**Land south of Cotefield Business Park Phase 2
adjacent to Blossom Field Road, Bodicote**

19/00050/DISC

Proposal: Discharge of Conditions 6 (levels) and 11 (landscaping) of
18/01309/REM

Project: Blossom Fields, Bodicote, Banbury
Client: Crest Nicholson
Date: July 2018
Scale: 1:200 @ A1
Drawing No: 1908 16 I
Rev:

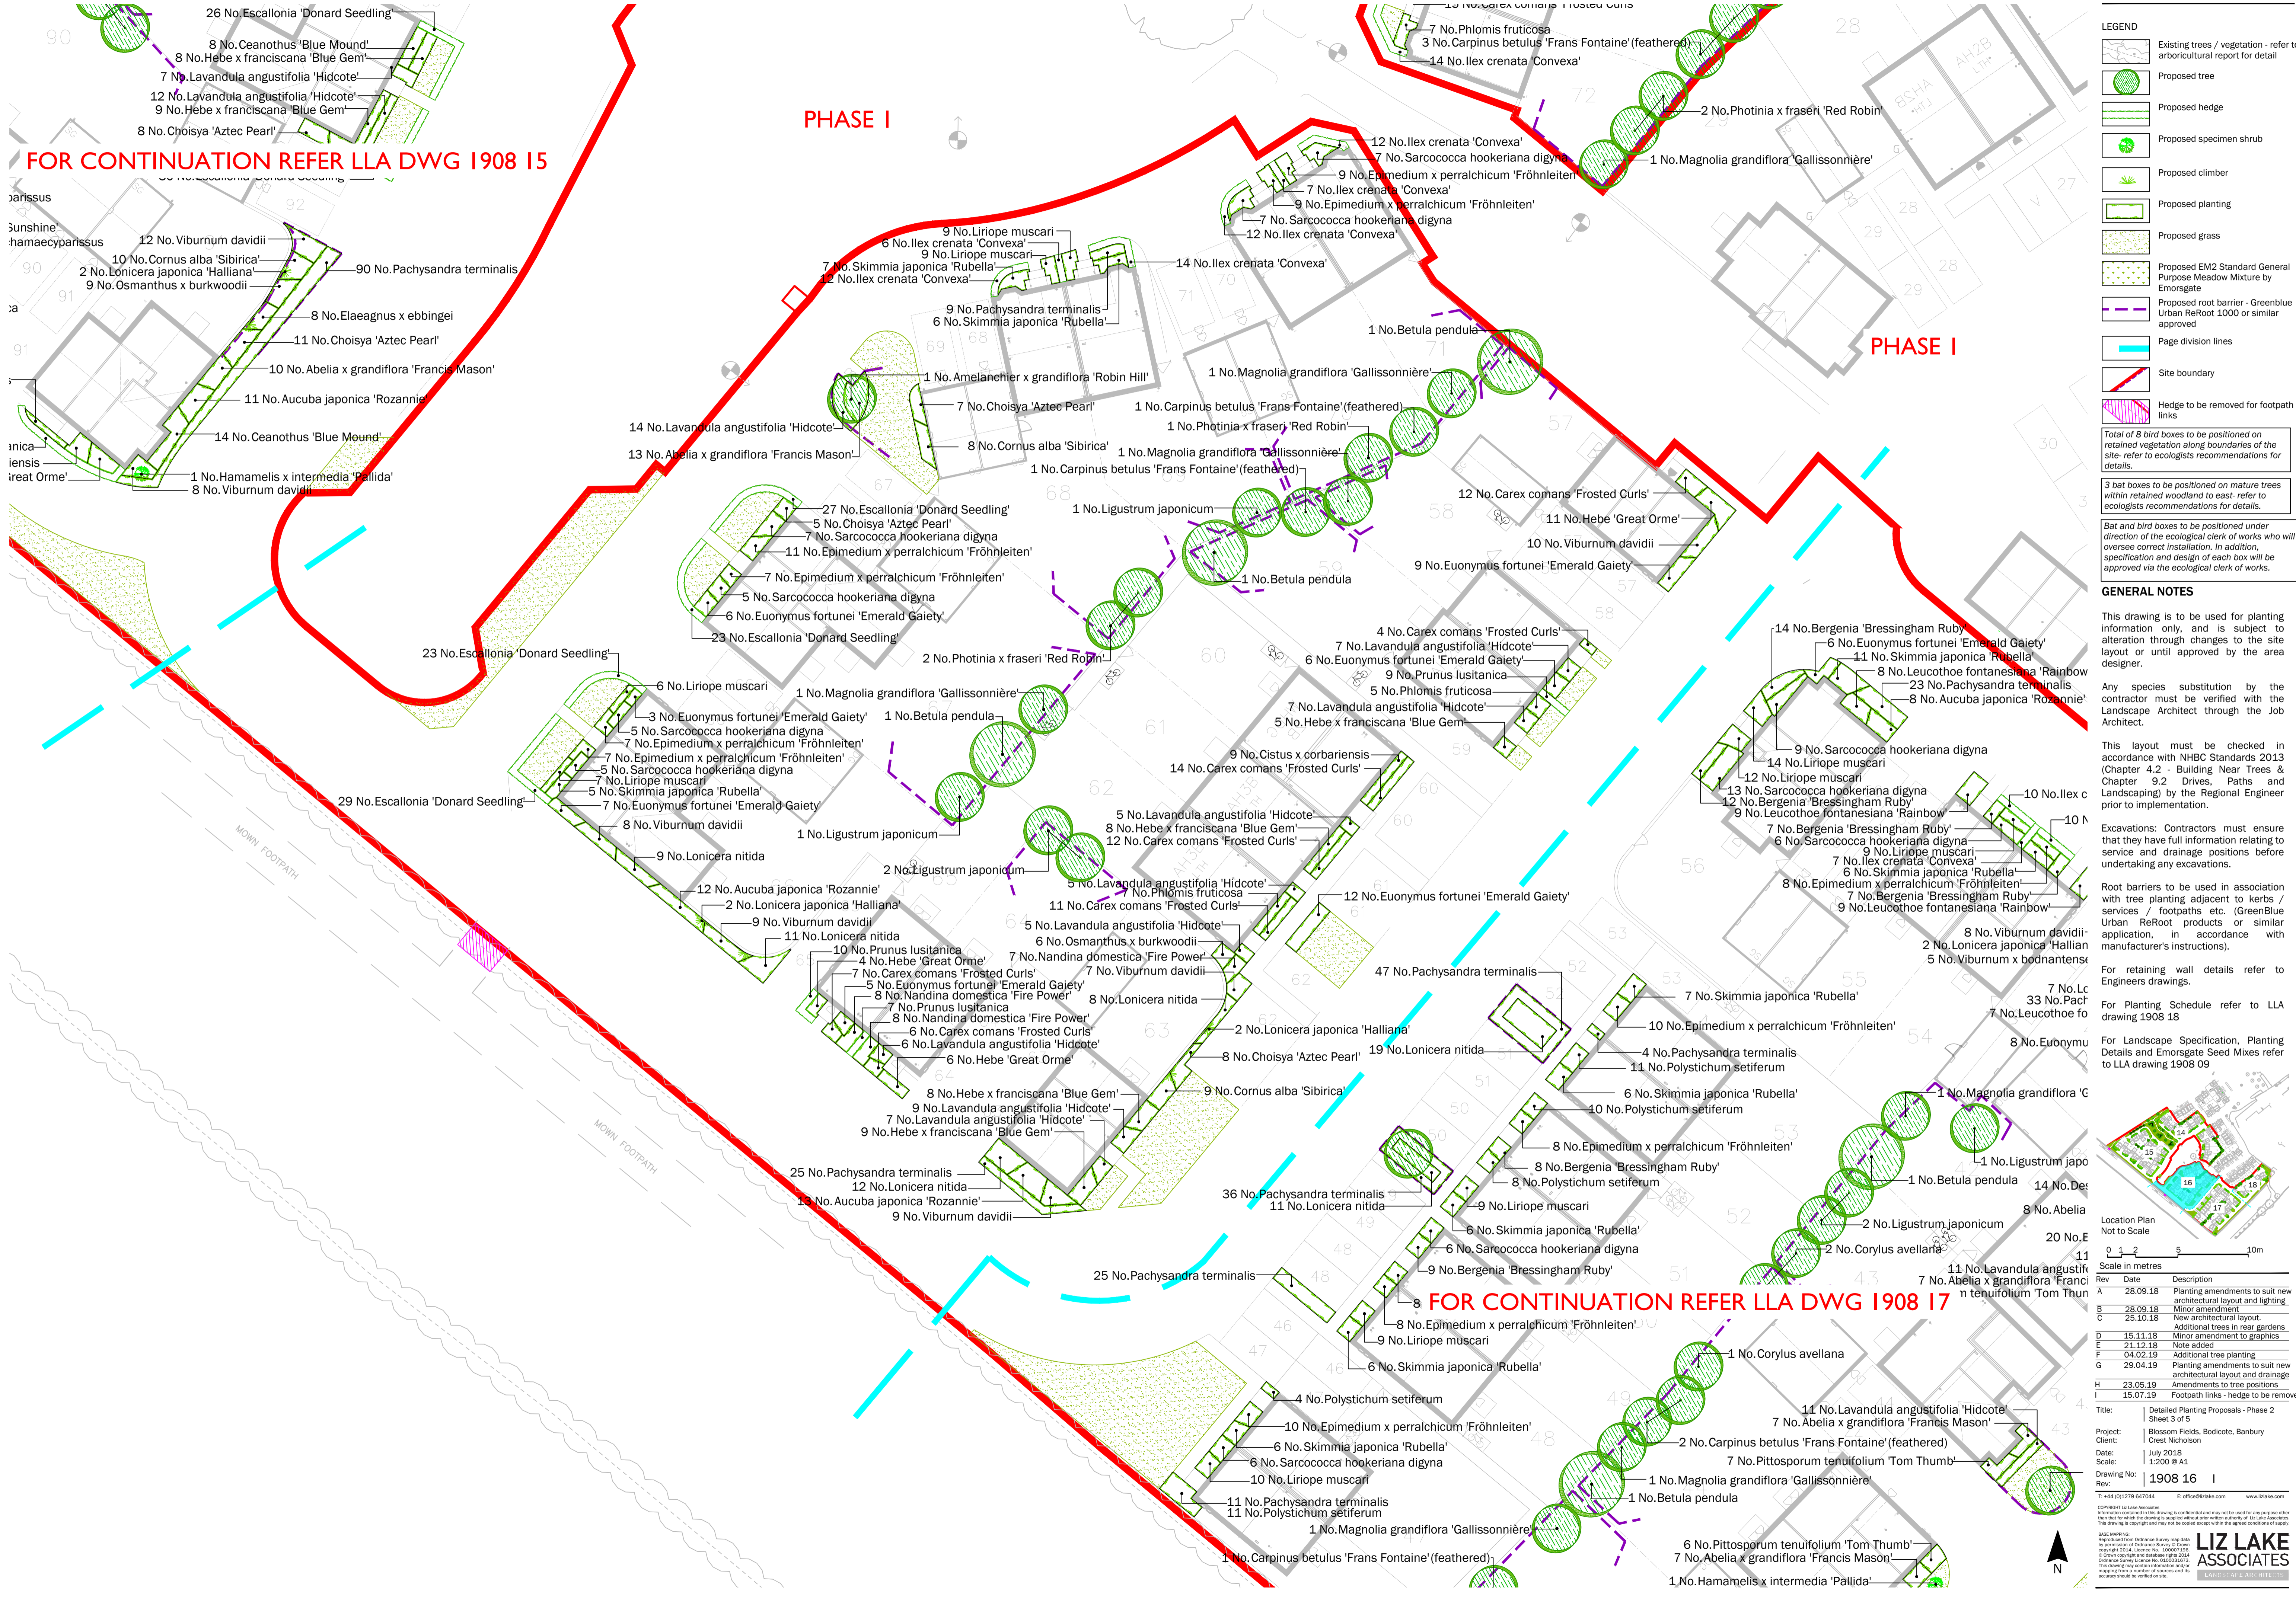
- 4.12. Condition 11 requires the submission of a landscaping scheme for the development. As a result of protracted discussion between officers and applicant a revised landscaping scheme has been submitted, and drawings "1908 14 E", "1908 15 J", "1908 16 I", "1908 17 E" and "1908 18 F" refer. The submitted details are considered acceptable.
